EL PASO COUNTY

DEPARTMENT OF PARKS AND COMMUNITY SERVICES

Subject: BTR Storage CS Rezone - (CS232)

The Parks and Community Services Department has reviewed the BTR Storage Commercial Service Rezone application and is submitting the following administrative comments on behalf of El Paso County Parks.

# ABTR STORAGE REZONE MAP

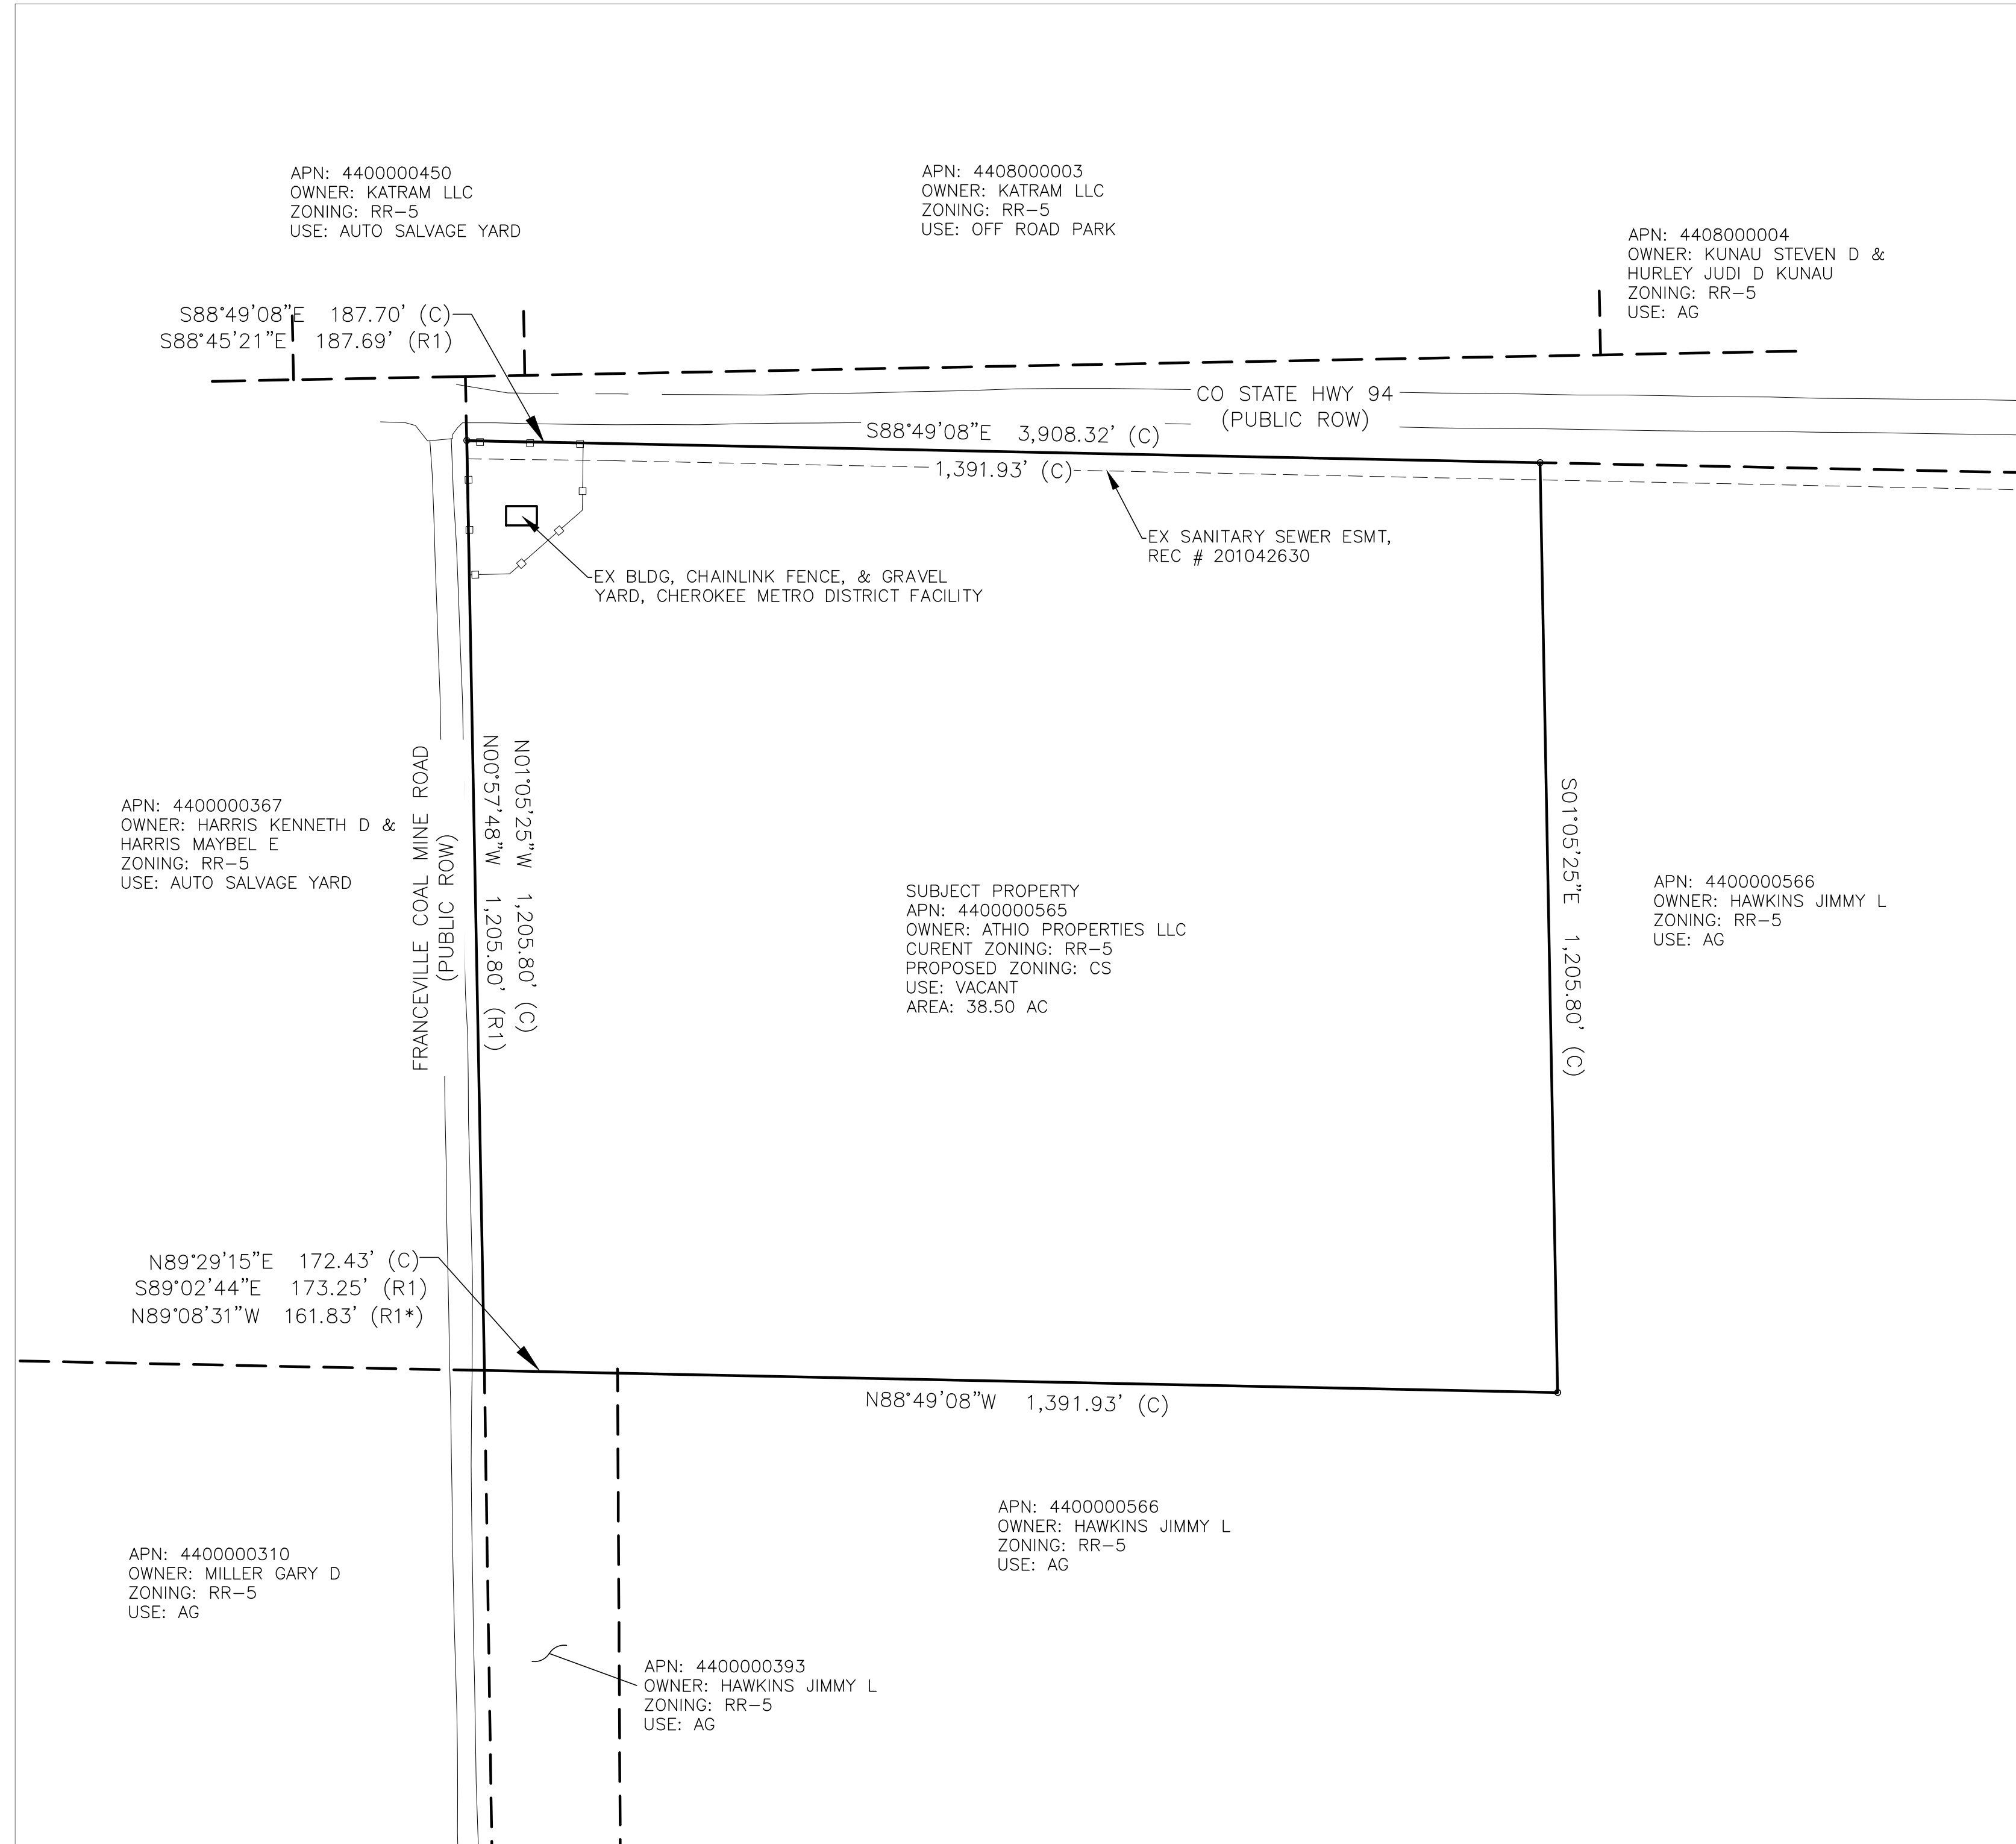
The El Paso County Parks Master Plan identifies two master-planned trails adjacent to the proposed facility. The proposed Highway 94 Bicycle Route runs east and west along Highway 94. This proposed trail will not be impacted by the project because it will be accommodated within the public right-of-way. The proposed Highway 94 Primary Regional Trail also runs east and west along Highway 94. This proposed trail would be impacted by the proposed facility because its alignment is on the south side of Highway 94.

Parks staff provides notice that the Highway 94 Primary Regional Trail is planned for 25' south of the right of way of Highway 94. The County encourages that the landowner provide a 25-foot-wide public trail easement along the south side of Highway 94 that allows for the construction and maintenance by El Paso County of the Highway 94 Primary Regional Trail.
